**Re: Chao/Limary Residence
Grading and Drainage Plan
Engineer's Stamp Date 9-17-14 (E23D003Q)**

Based upon the information provided in your submittal received August 28, 2014, the above referenced plan cannot be approved for Building Permit until the following comments are addressed:

GRADING & DRAINAGE PLAN

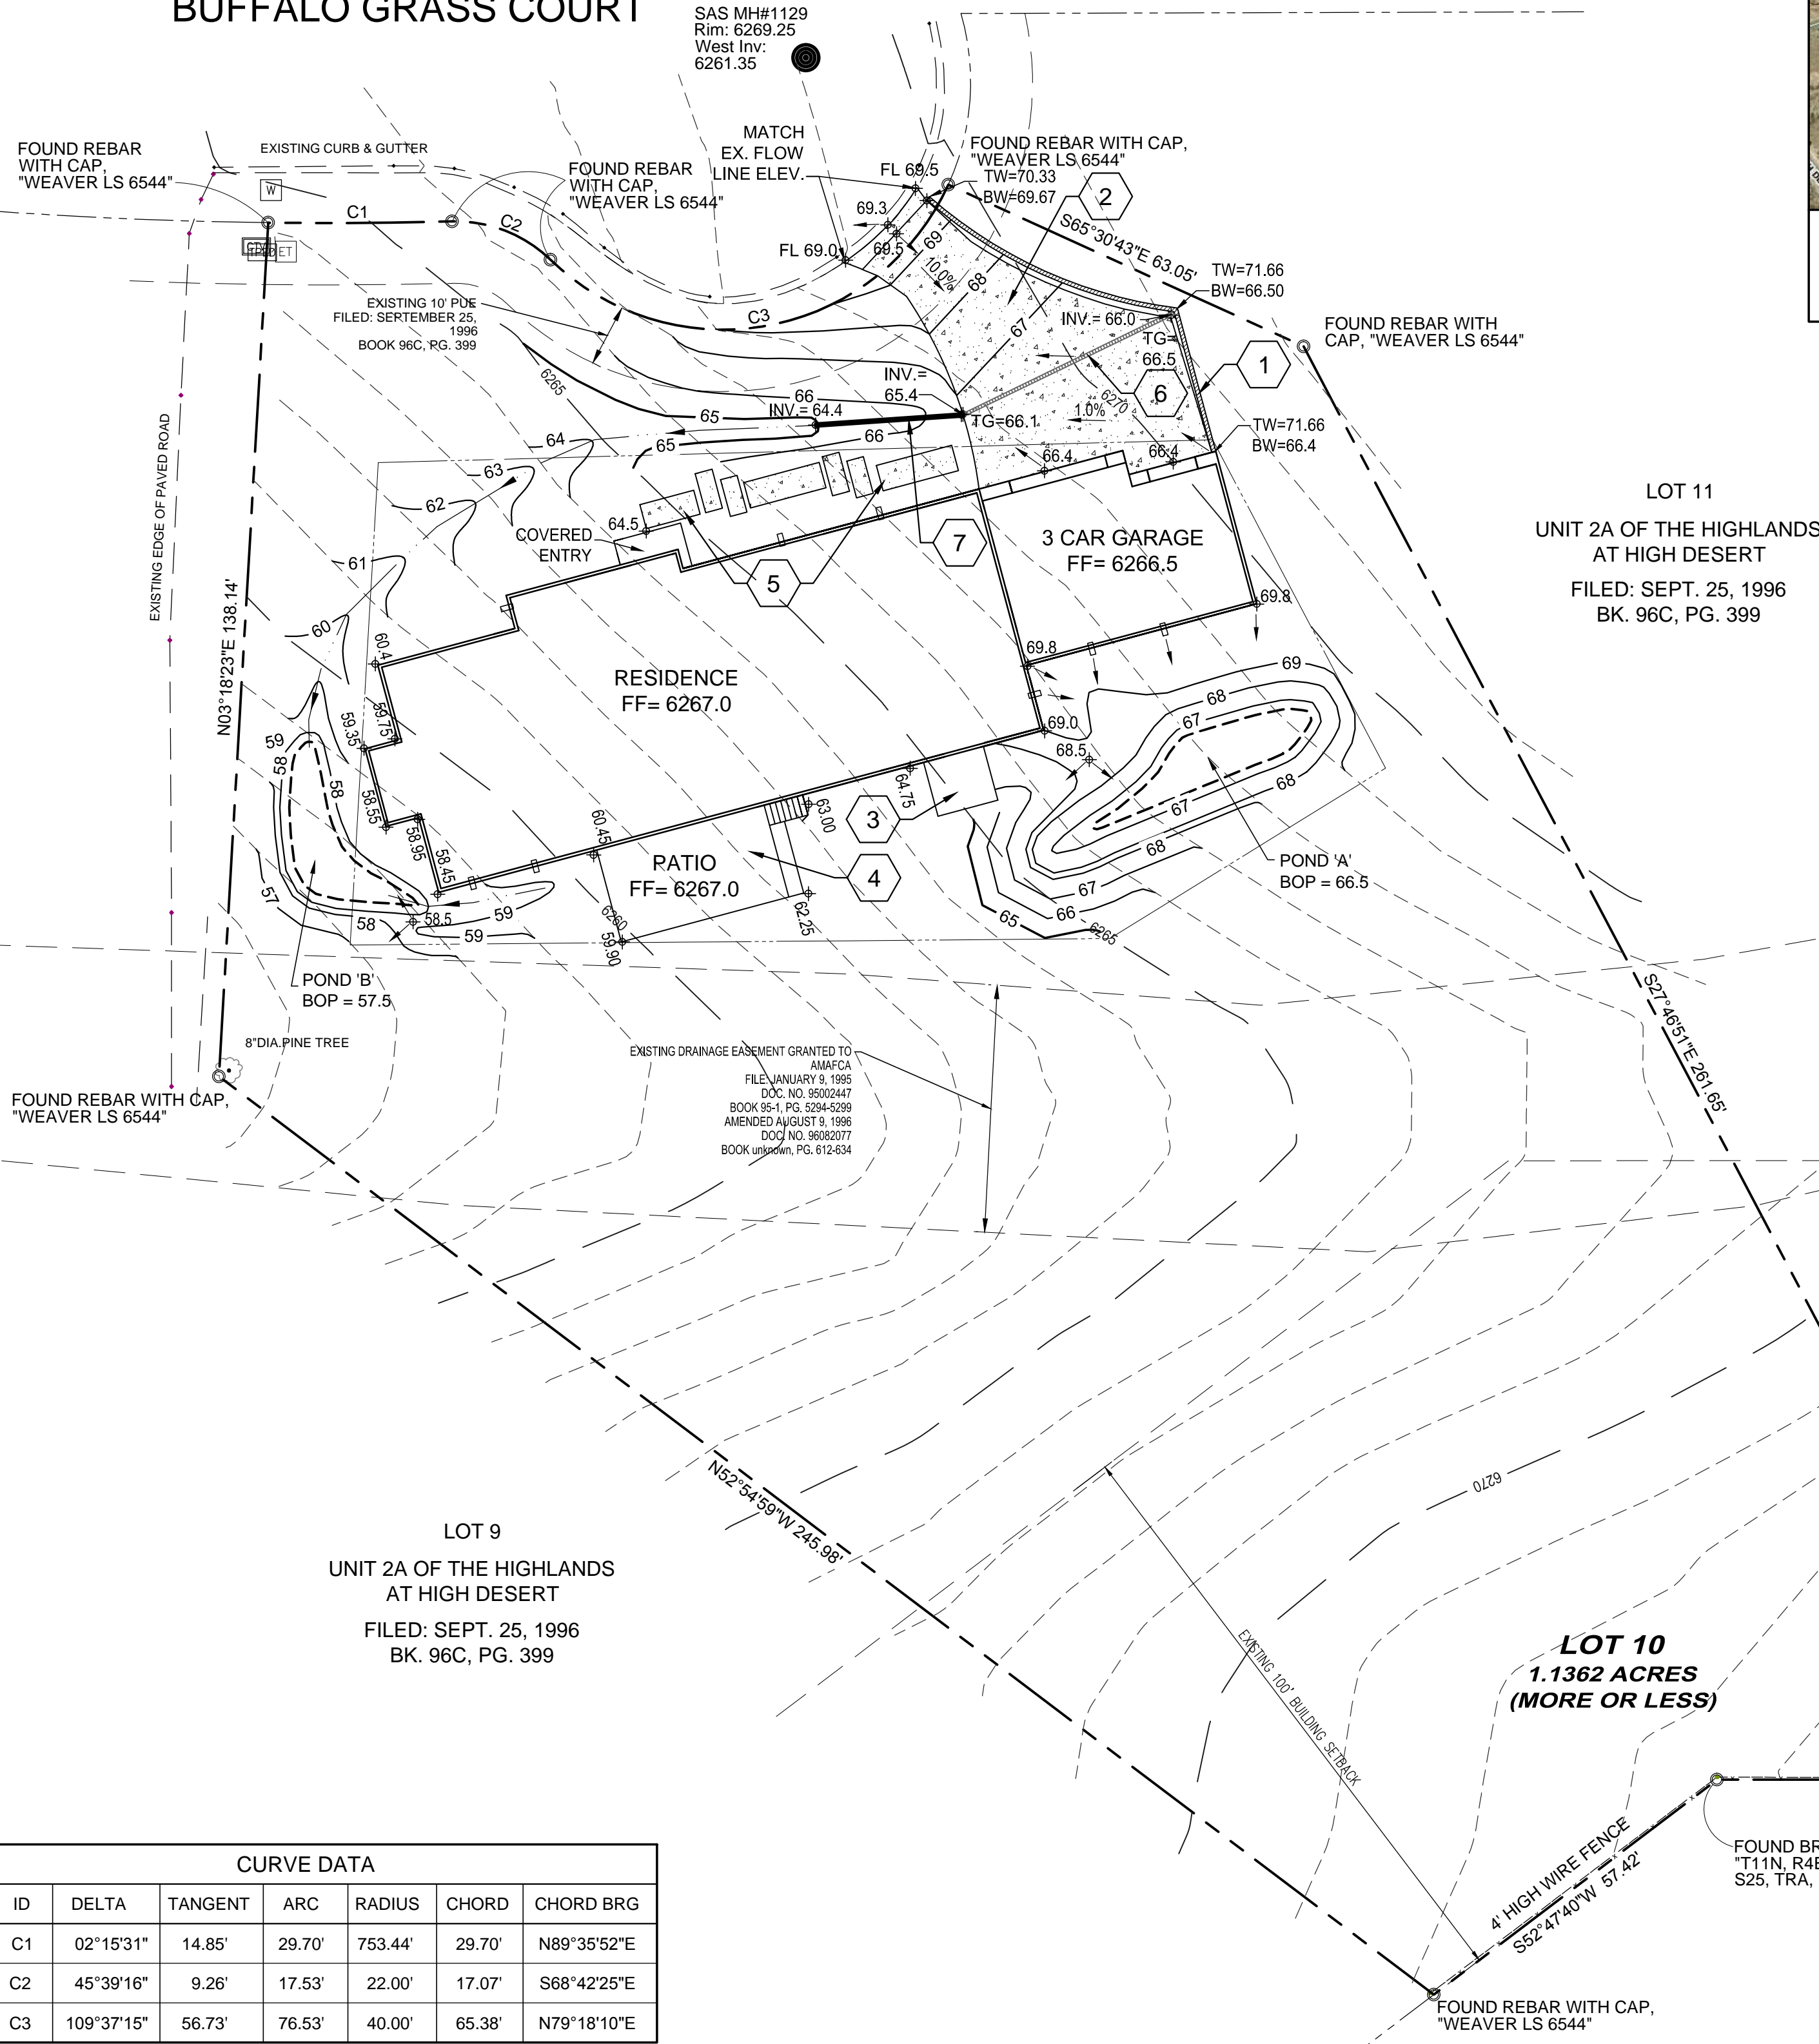
1. Provide a vicinity map with the site outlined on it.
2. Include a FIRM map and discussion of the Flood Zone the site is in.
3. A benchmark was provided. Is that a TBM? Identify it on the site or provide a tie to one if it is not on the site.

4. Provide a narrative. Indicate how the design of the property is in accordance with the Master Drainage Plan, High Desert – Tract 14B (E23D003K). Include a discussion of existing and proposed conditions off-site and on-site. Are flows coming from off-site? How are those being managed? Indicate all your existing and proposed design assumptions. Land Treatments B and C should be included for the proposed condition. The soil will be disturbed for the front yard, swale and ponds. There are slopes greater than 10% being proposed. See Table A-4 in Chapter 22 for the description of land treatments.

5. What is happening with the grades on the south and west sides of the property? There is a drop of 9 feet from the house to the pond on the west, but no wall of any kind indicated. On the south side, what are the grades against the house? How are the proposed grades being tied into the existing grades on the south and east sides? What are the grades for the patio and deck? Show any stem walls and grades adjacent to the stem walls.

6. What are the flow line elevations in the cul-de-sac that are being matched? Is the higher side of the proposed driveway going to be above that for the full length of the water block? Is there enough of a water block to prevent flows from entering and going down the driveway?

7. Show the entire property. Provide a second sheet if necessary.
8. Discuss how the First Flush is being retained. Per the City Drainage ordinance, the 90th Percentile Storm Event, which is 44 inches, is to be managed. Reduce 0.44 inch by the 0.1 inch for the initial impervious abstraction in Table A-6 of Section 22 of the DPM. Multiply the remaining 0.34 inch by your impervious area. This is the portion to retain.
